Re: **Popeyes Juan Tabo**
840 Juan Tabo Blvd NE
Traffic Circulation Layout
Engineer's/Architect's Stamp 9-13-24 (K22D035A)

Based upon the information provided in your submittal received 10-2-24, the above referenced plan cannot be approved for Building Permit until the following comments are addressed:

8 ADA PARKING & PEDESTRIAN ACCESS
C702 SCALE: N.T.S.

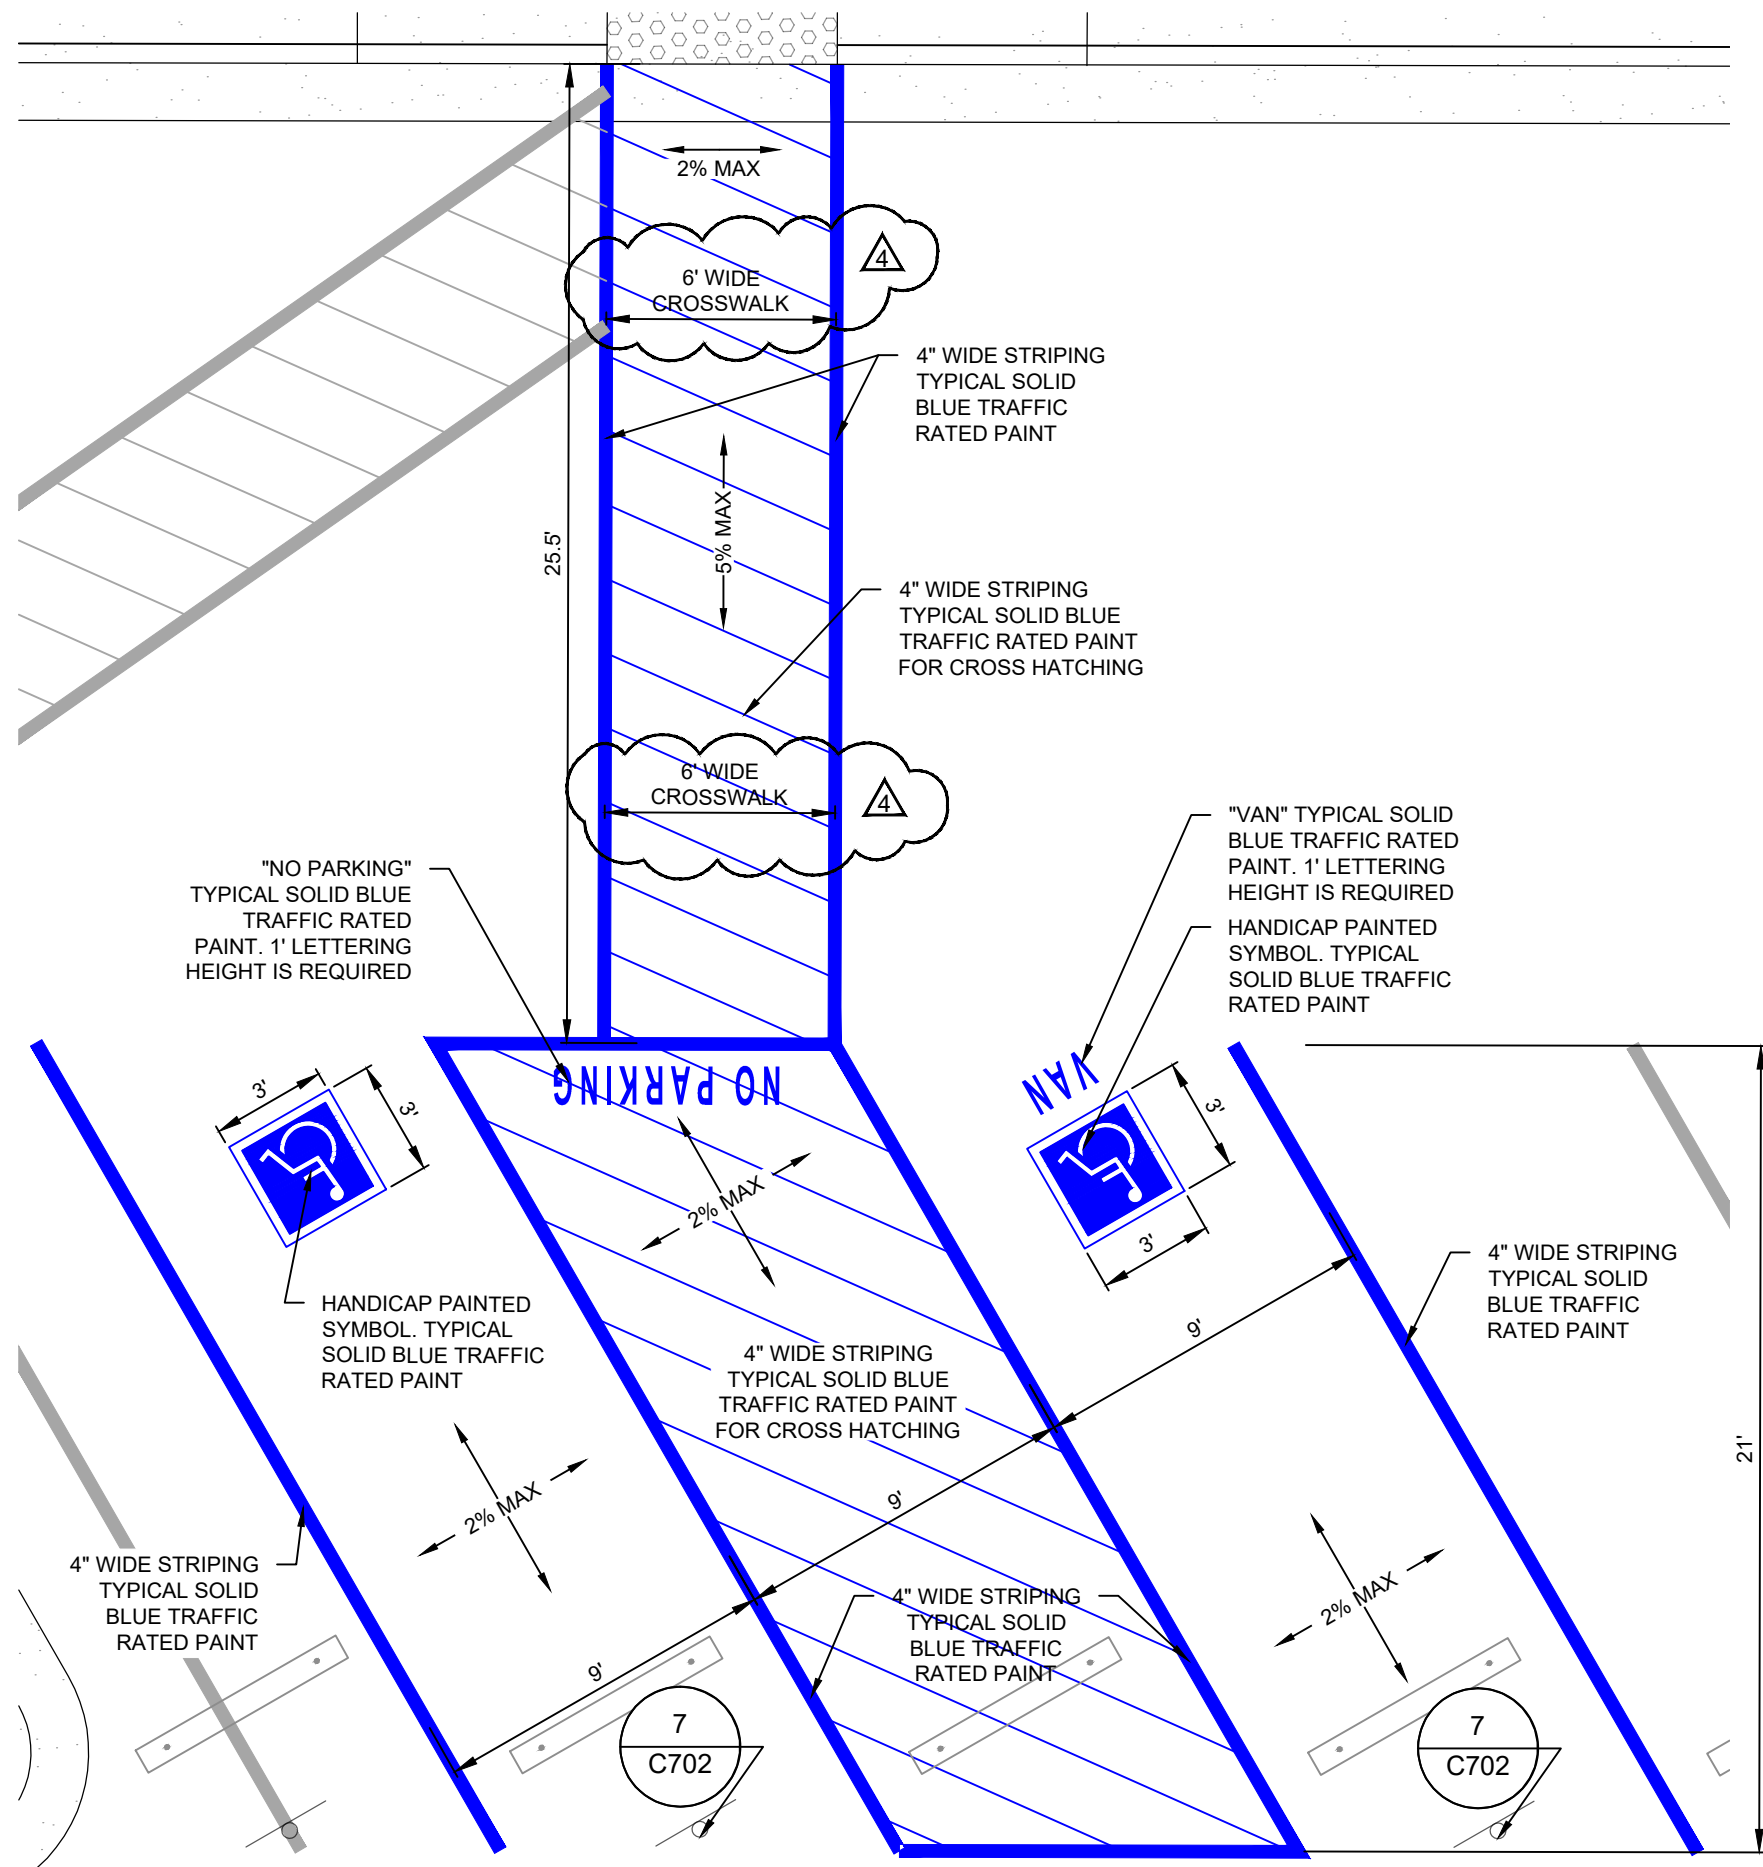
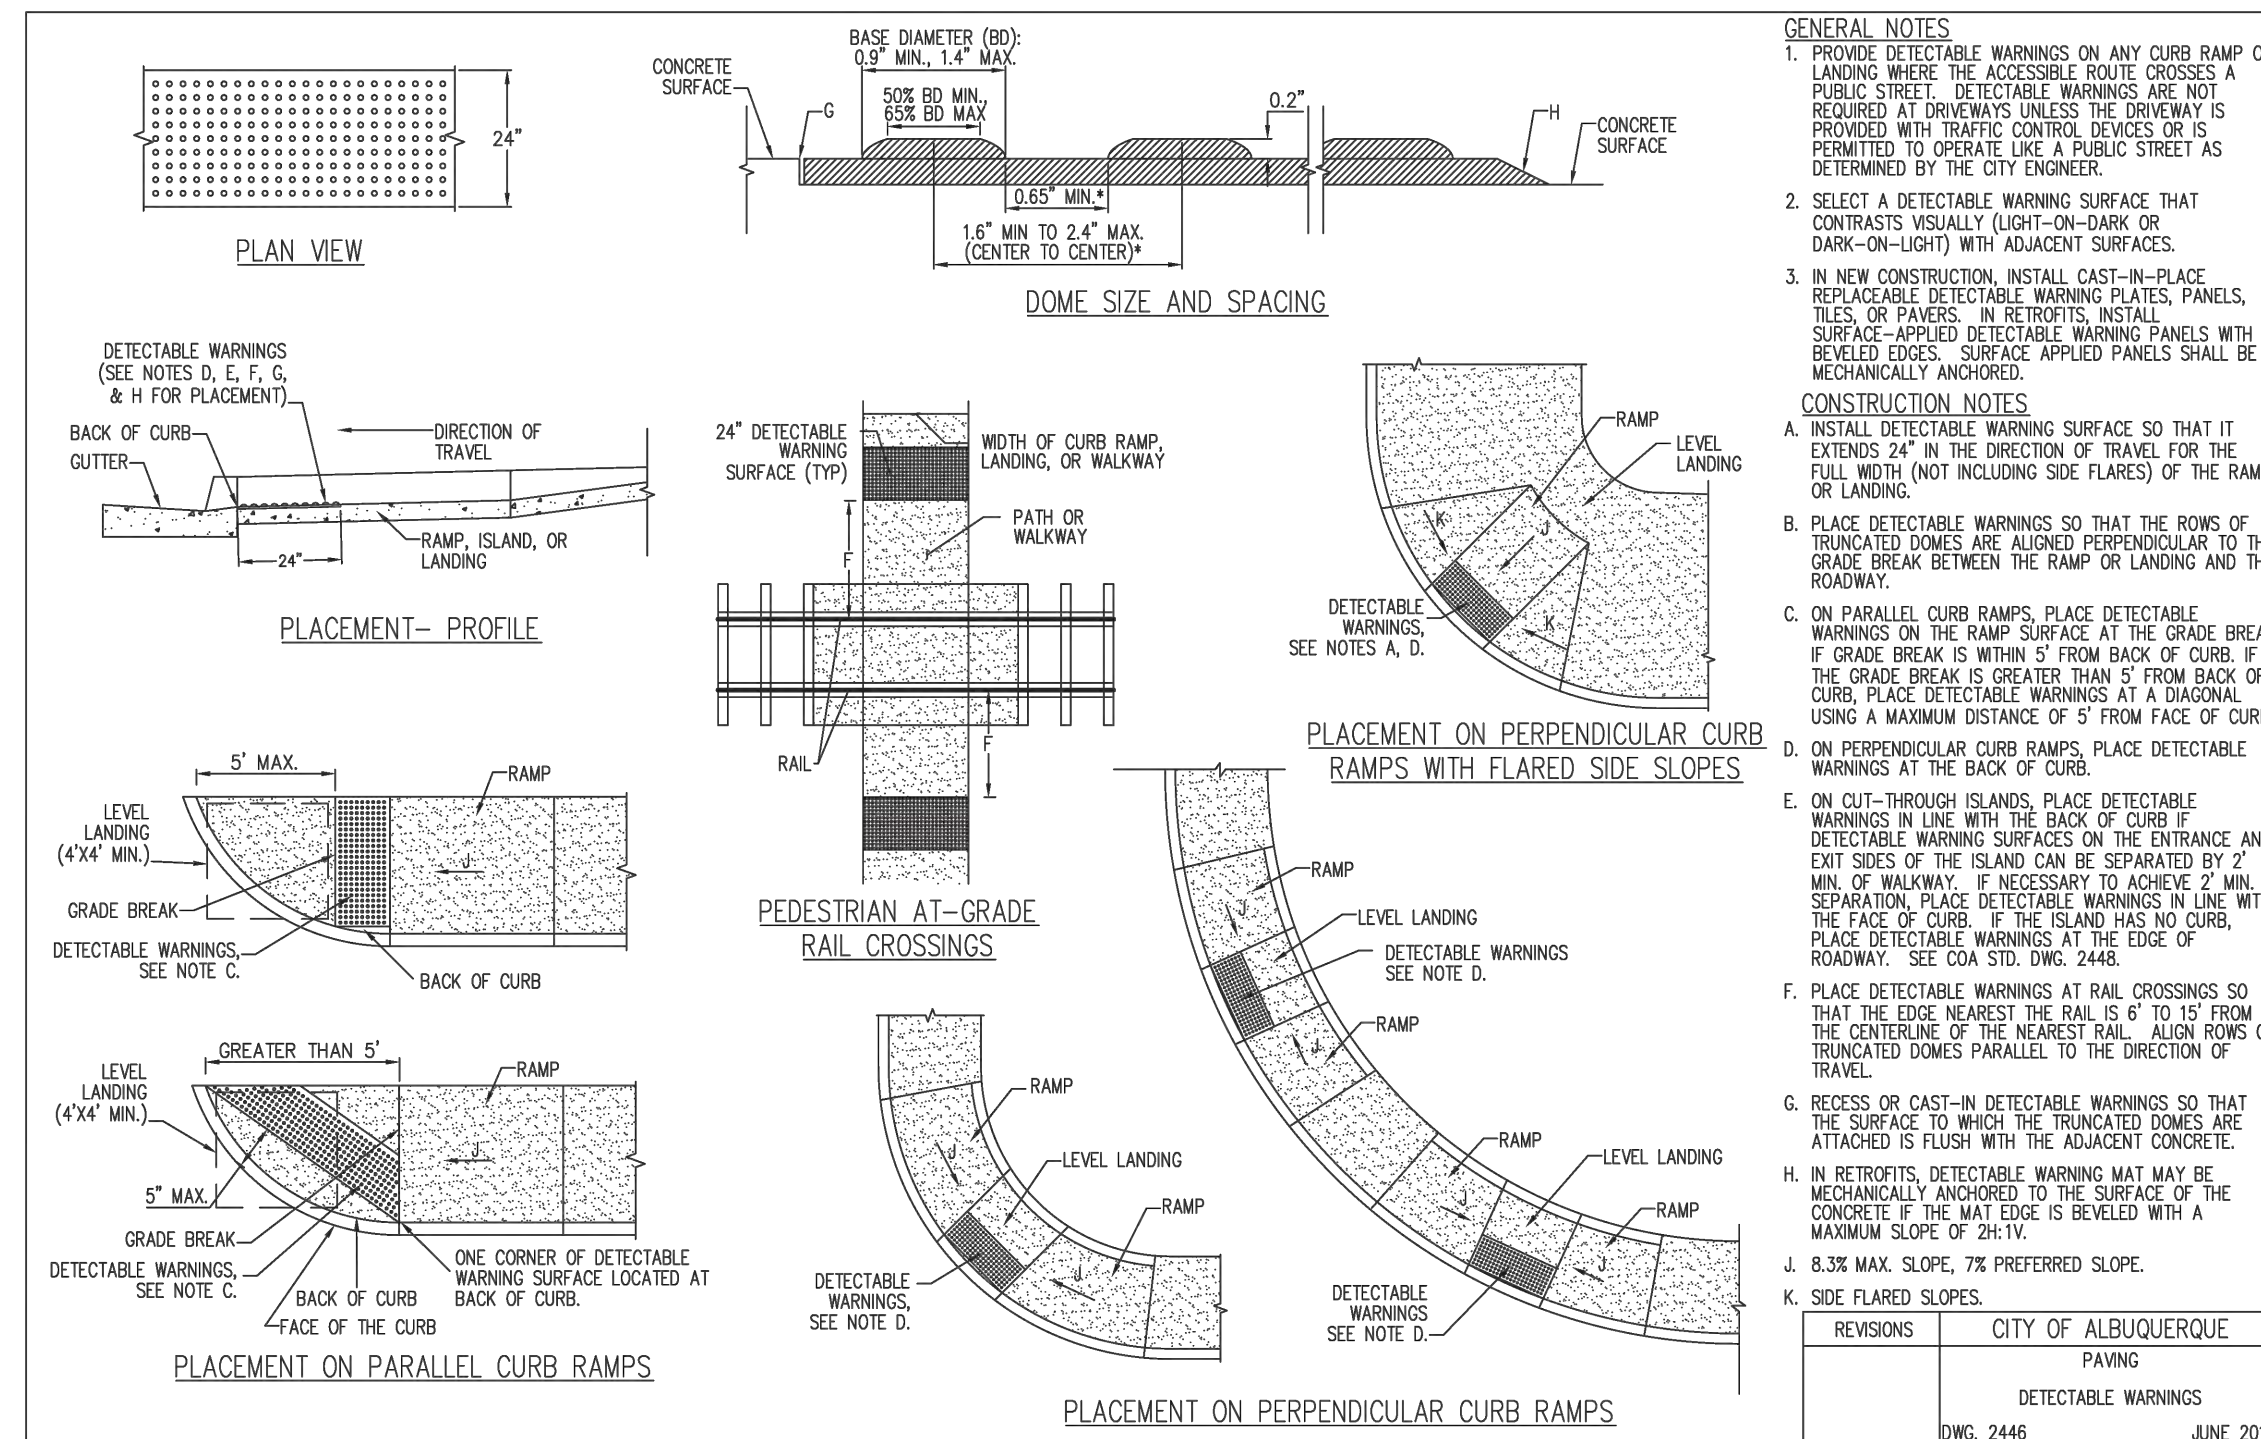
5. Per DPM, a 6 ft. wide ADA accessible pedestrian pathway is required from the ADA parking stall access aisles to the building entrances. Please revise the width to 6' (keyed notes 12 and 13). **SMA has updated the access aisle to 6' on all sheets.**
6. All one-way drives shall have "One Way" and "Do Not Enter" signage and pavement markings. Please show detail and location of posted signs and striping. **SMA included details and signage for one way drive aisles on the TCL.**
7. The minimum drive through lane width is 12 feet with a 25 foot minimum radius (inside edge) for all turns. (A 15 foot radius can be used with an increase in lane width to 14 feet). Please dimension all lane widths and radii. **SMA has adjusted the site plan accordingly, please see dimensional site plan for dimensions.**

10 CONCRETE WHEEL STOP
C702 SCALE: N.T.S.

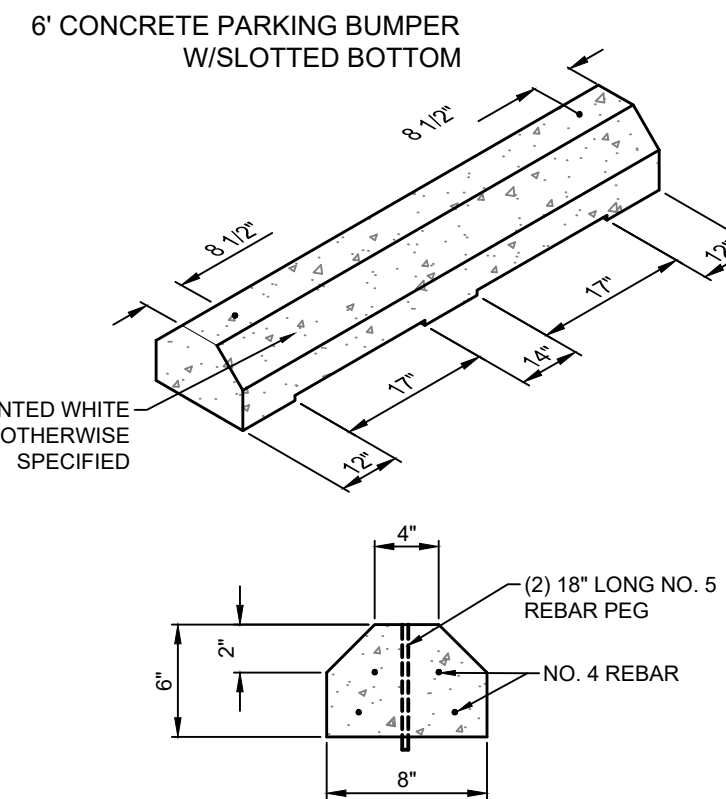
11. Relocate the parking blocks (Stops) by 60 deg angle and 2' away from end of the parking stall. Add parking blocks (Stops) for the north side parking stalls. **SMA has adjusted/added the concrete bumpers on the TCL.**
